CHENNAI METROPOLITAN DEVELOPMENT AUTHORITY
Thalamuthu Natarajan Building, No.1, Gandhi Irwin Road,
Egmore, Chennai - 600 008
Phone : 28414855 Fax: 91-044-28548416
E-mail: mscmda@tn.gov.in
Web site: www.cmdachennai.gov.in

Letter No. L1/6022/2020

Sub: CMDA - Area Plans Unit - Layout Division - Planning Permission – Proposed Sub-division of the property into 4 No. of plots for industrial use comprised in S.No.375/2A1 of Ayanambakkam Village, Poonamallee Taluk, Thiruvallur District, Thiruverkadu Municipal limit – Approved - Reg.

SUB-DIVISION OF INDUSTRIAL SITES IN S.No. 375/2A1 OF AYANAMBAKKAM VILLAGE.

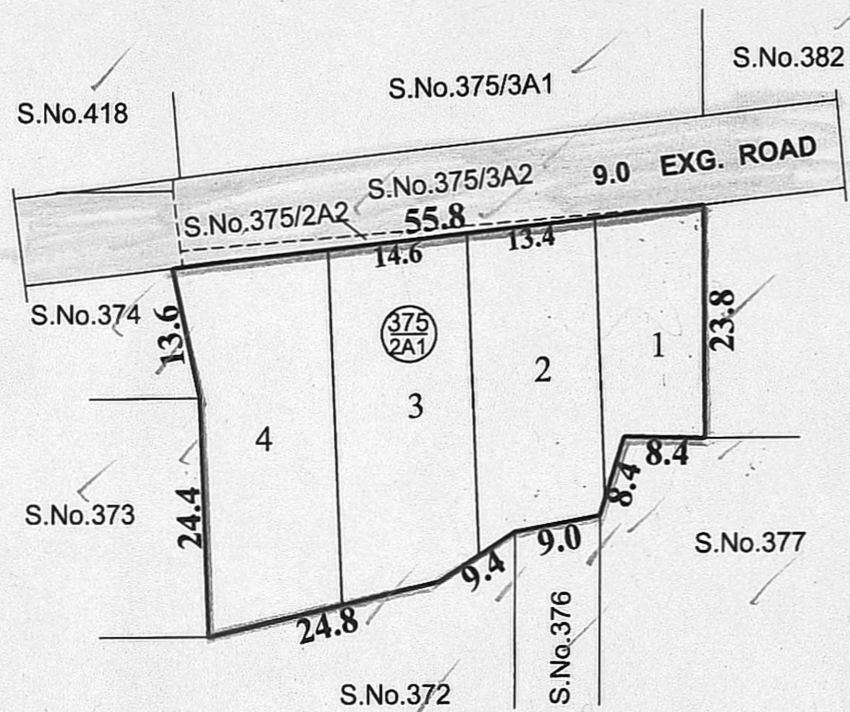
2. In the reference 8th cited, the applicant i.e. Tmt.Colleen Daniel made a request to revise the ^{sub-division} plan with respect to the dimensions of the site as per the rectified FMB Sketch for S.No.375/2A1 of Ayanambakkam Village furnished.

3. The representation of the applicant together with the revised FMB Sketch furnished for S.No.375/2A1 of Ayanambakkam Village has been examined and found that the revised FMB sketch for the site under reference furnished by the applicant tallying with the sketch annexed with the Rectification Gift Deed Doc. No.2766/2020 dated 25.02.2020 executed earlier for gifting of the road ^{sketch} lies on the northern side of the site.

4. Hence the revised sub-division plan by correcting the site boundary dimensions as per the revised FMB Sketch is prepared and approved in the same PPD/LO No.66/2020. Accordingly the revised sub-division approved plan is sent herewith for further action.

5. The Approved plan already sent in the reference 7th cited hereby stands cancelled .
